Martin Nugent
01254 828060
D3/11/0498

Drafted 20 October 2011

**Planning Application, Ribble Valley District
3/11/0498 The Eaves, Pendleton Road, Wiswell**

drawing title: PROPOSED SITE PLAN

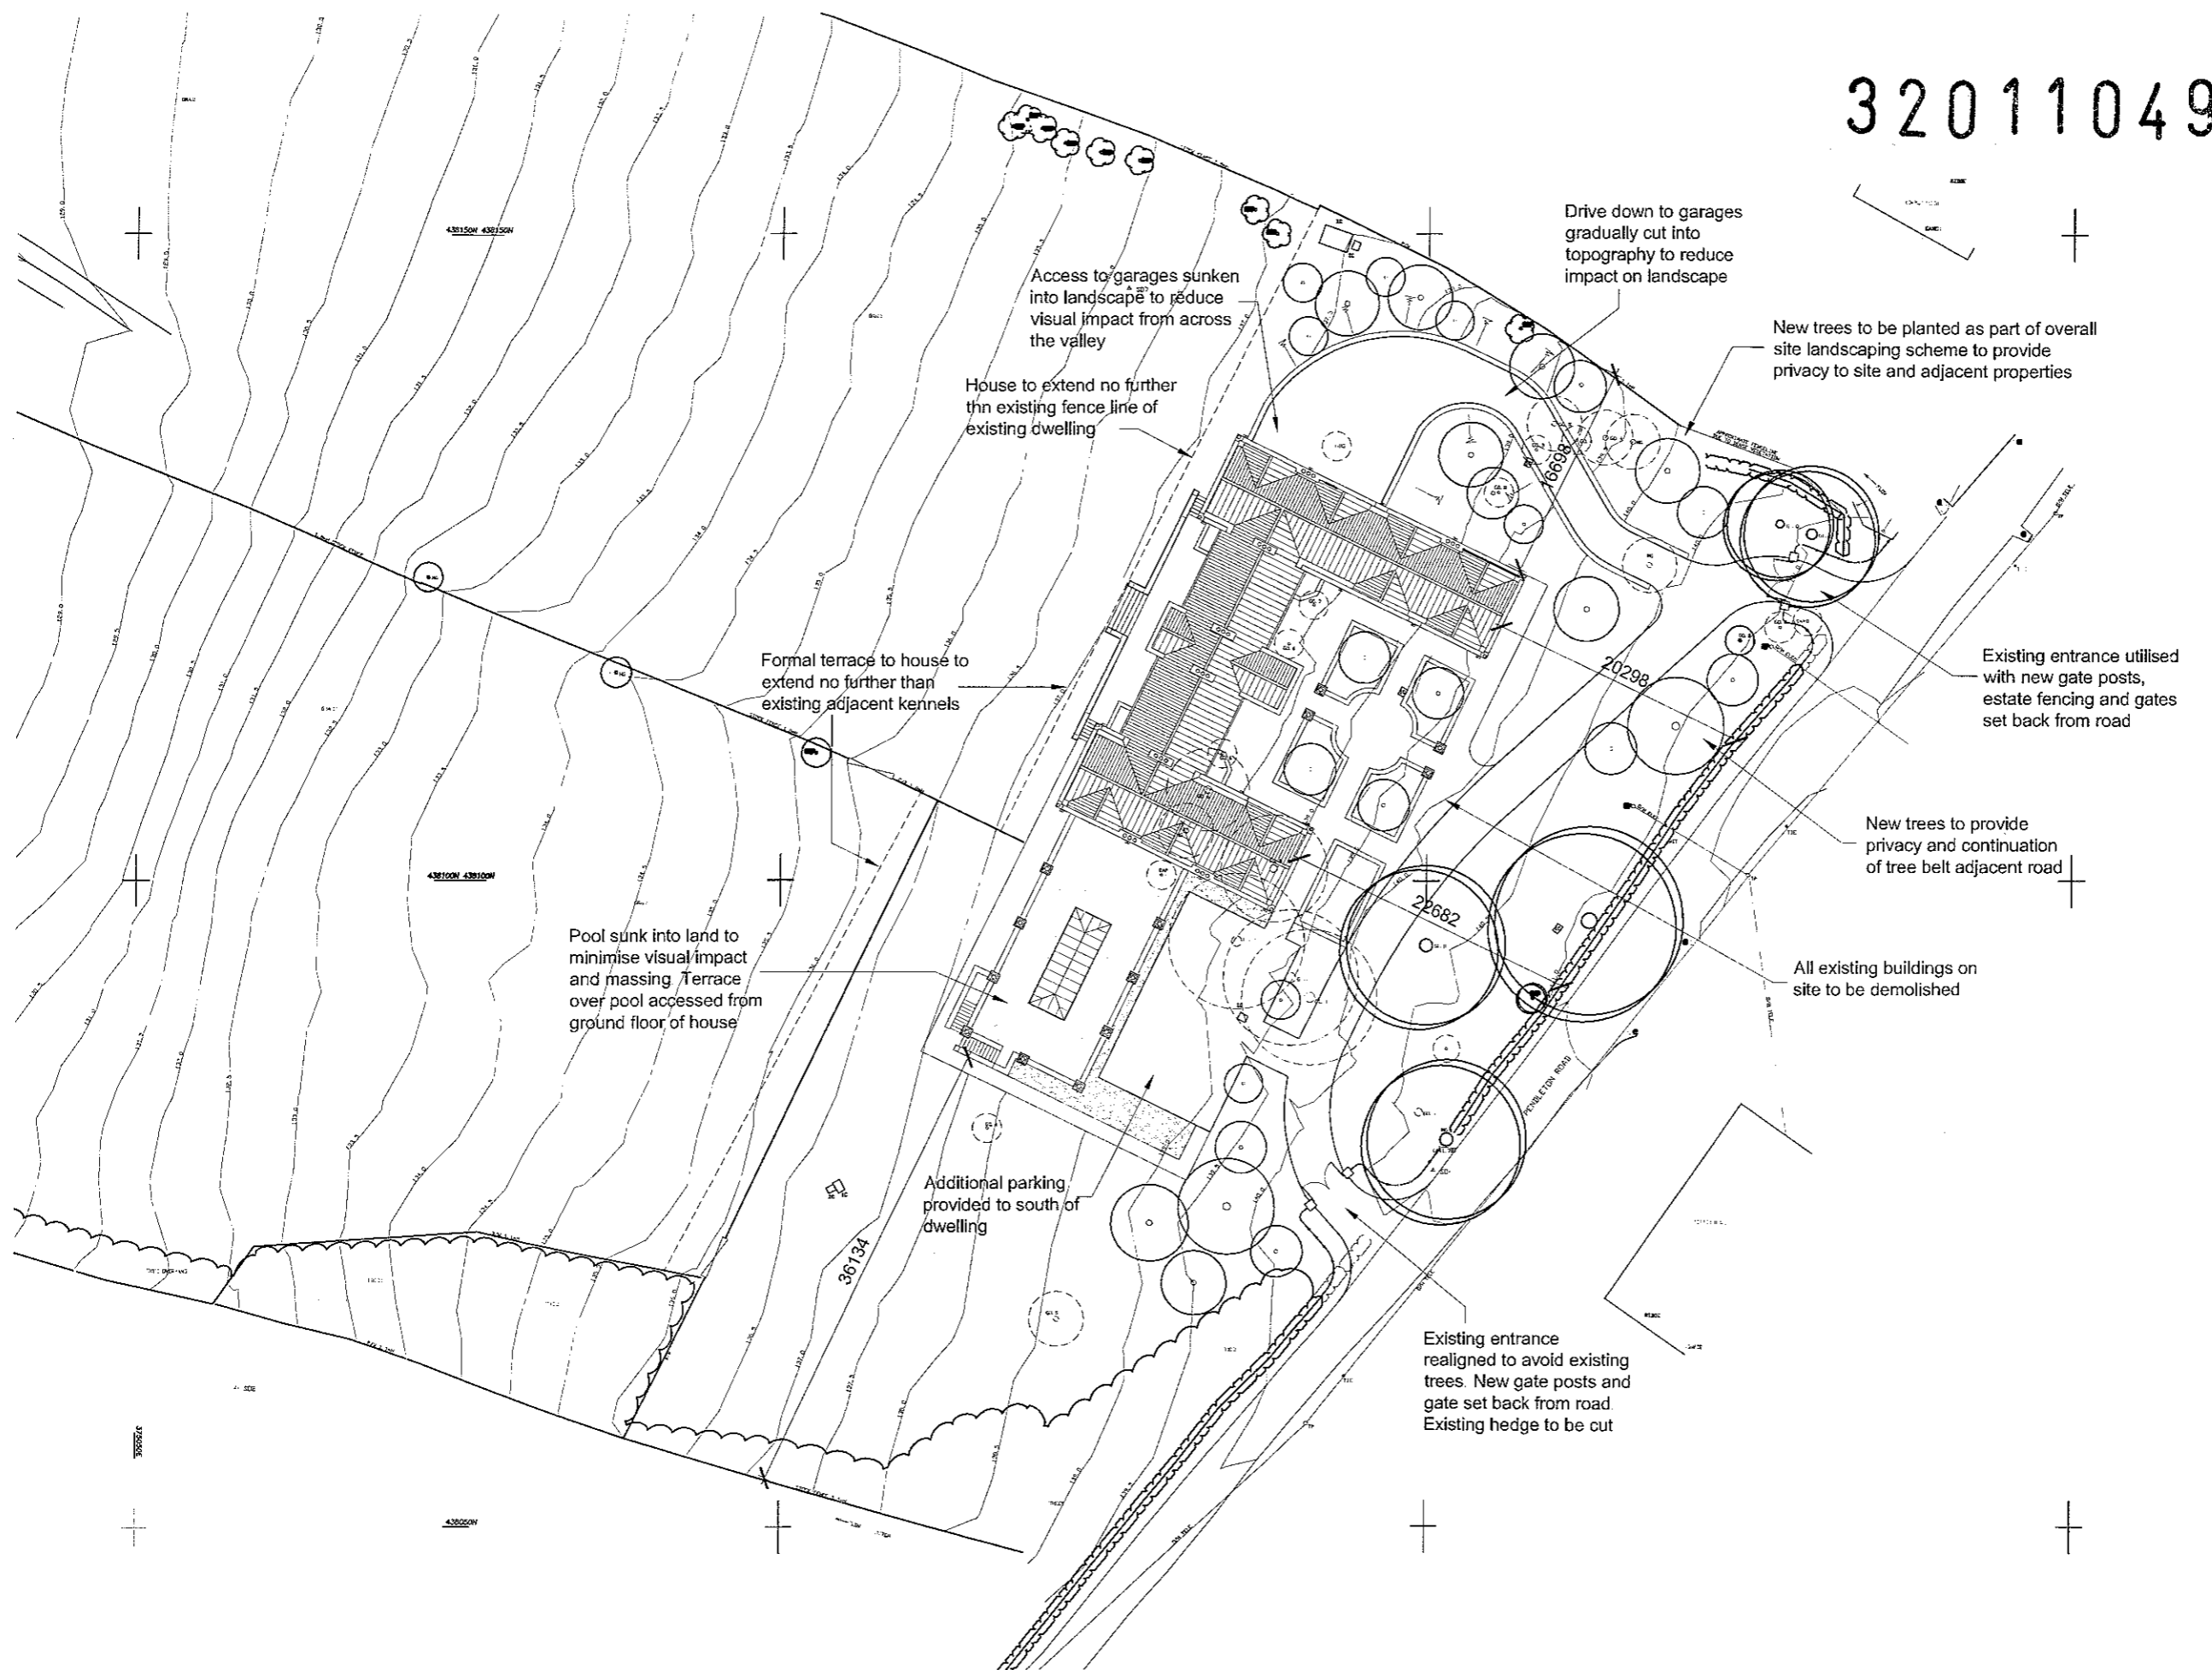
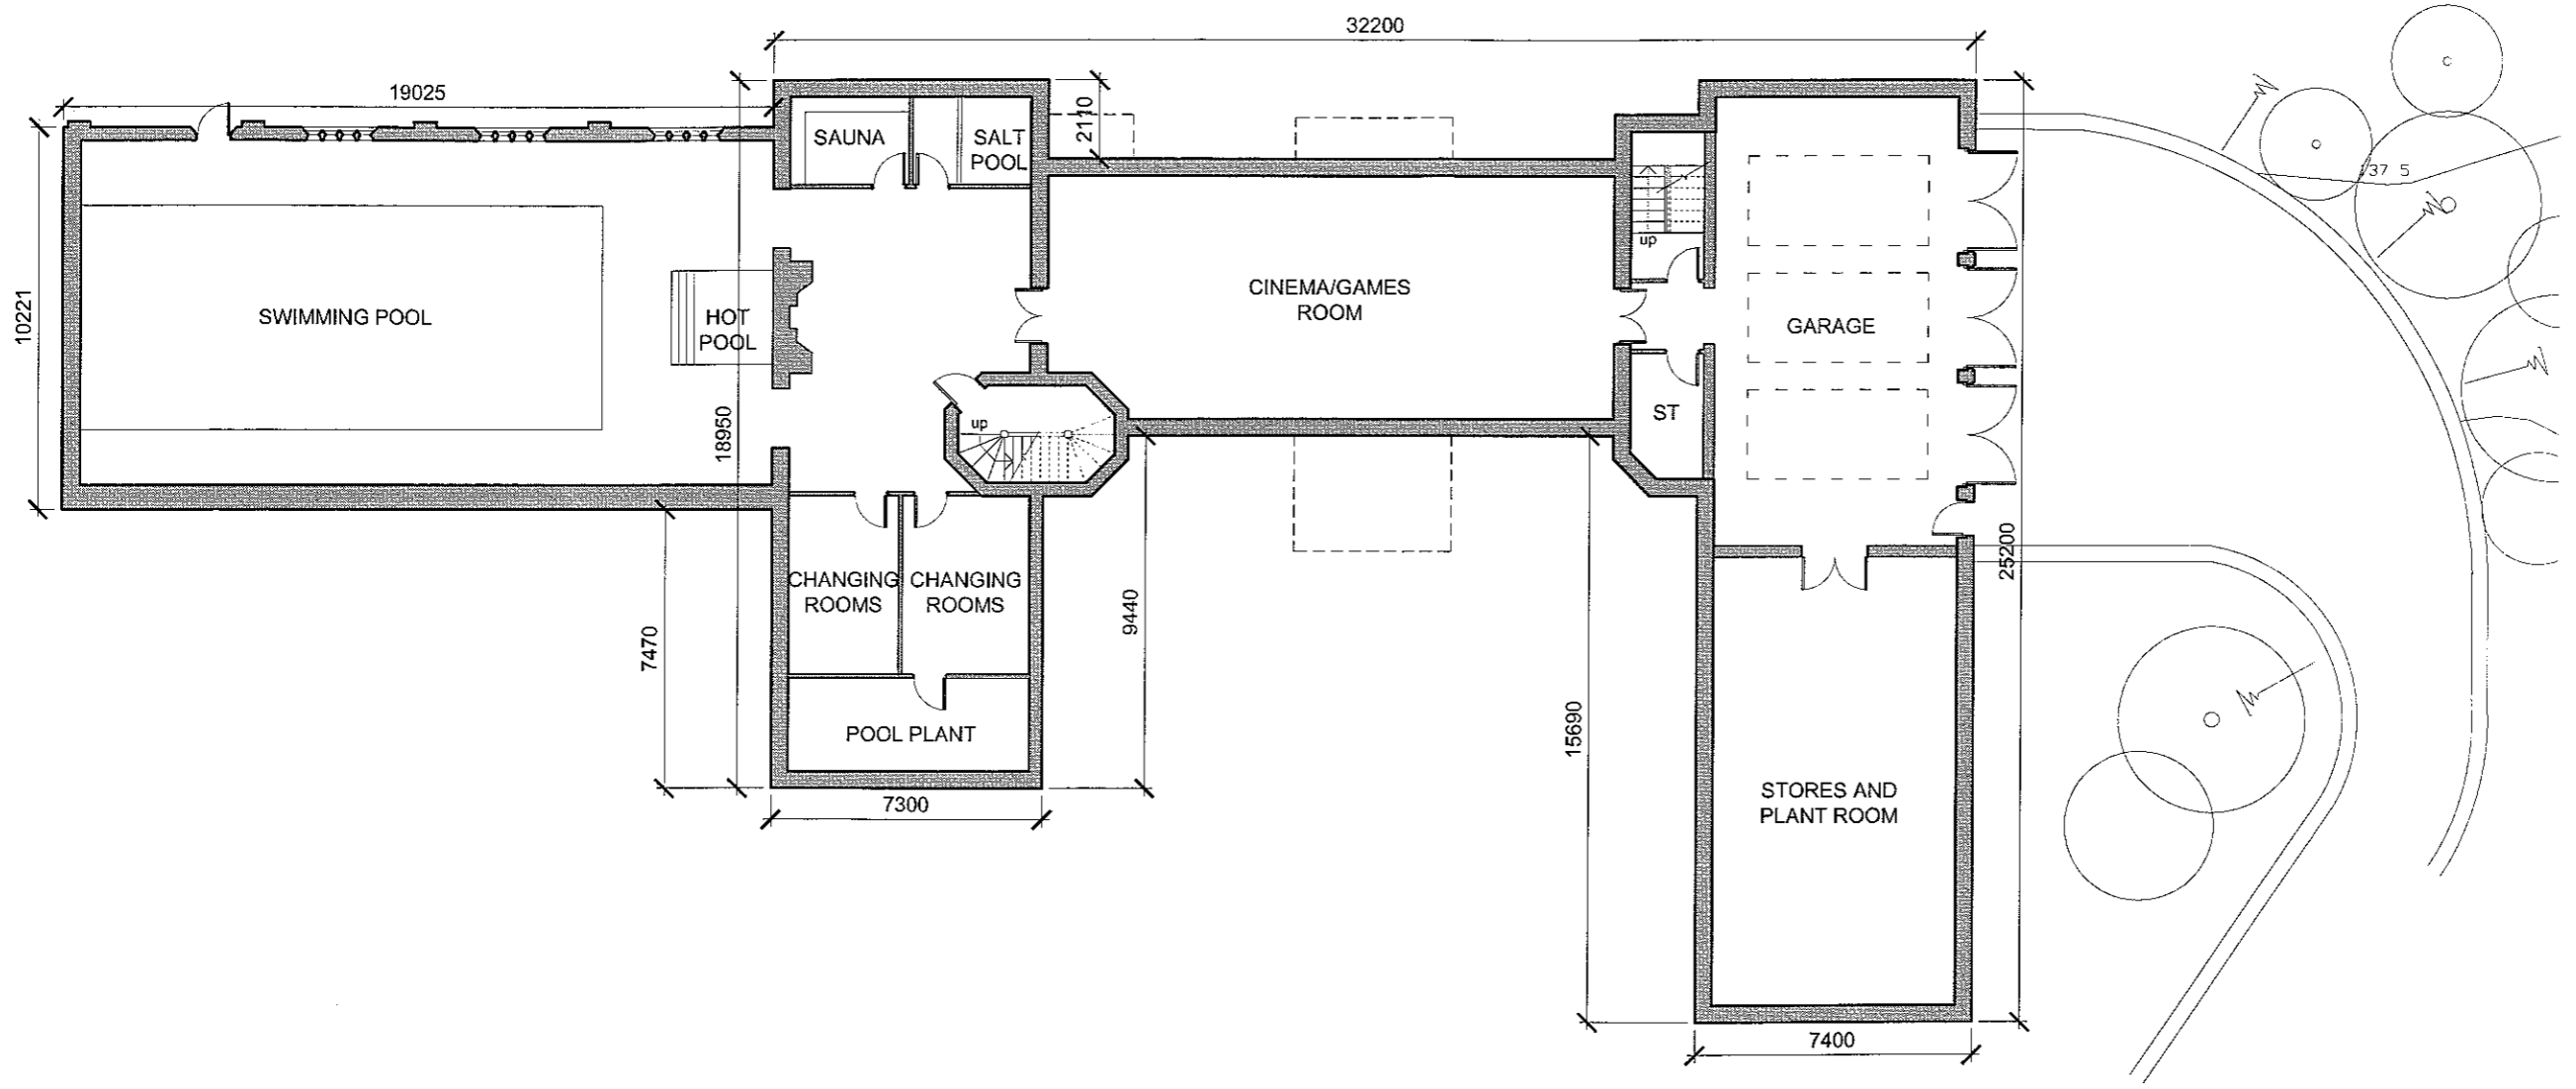
The plans provided do not give a clear indication of the sightlines that can be achieved from the site onto Pendleton Road. I recognise that reference is made in the supporting information to the realignment of the adjacent hedgerows, but the highway safety benefits are not made clear and the extent of the sightlines, measured from a point 2.4m back from the edge of carriageway, are not made explicit. For a property of this type exiting onto a road of this width, I would anticipate minimum sightlines of 2.4m by 90m.

However, the plans show two points of access to the site, with a narrow service road across the front of the property. The "one way" operation of this service road will not be apparent to visitors approaching the site and I would recommend that one point of access would be preferable. This would rationalise the potential movements to and from the site and could be supported by a turning head to north end of site.
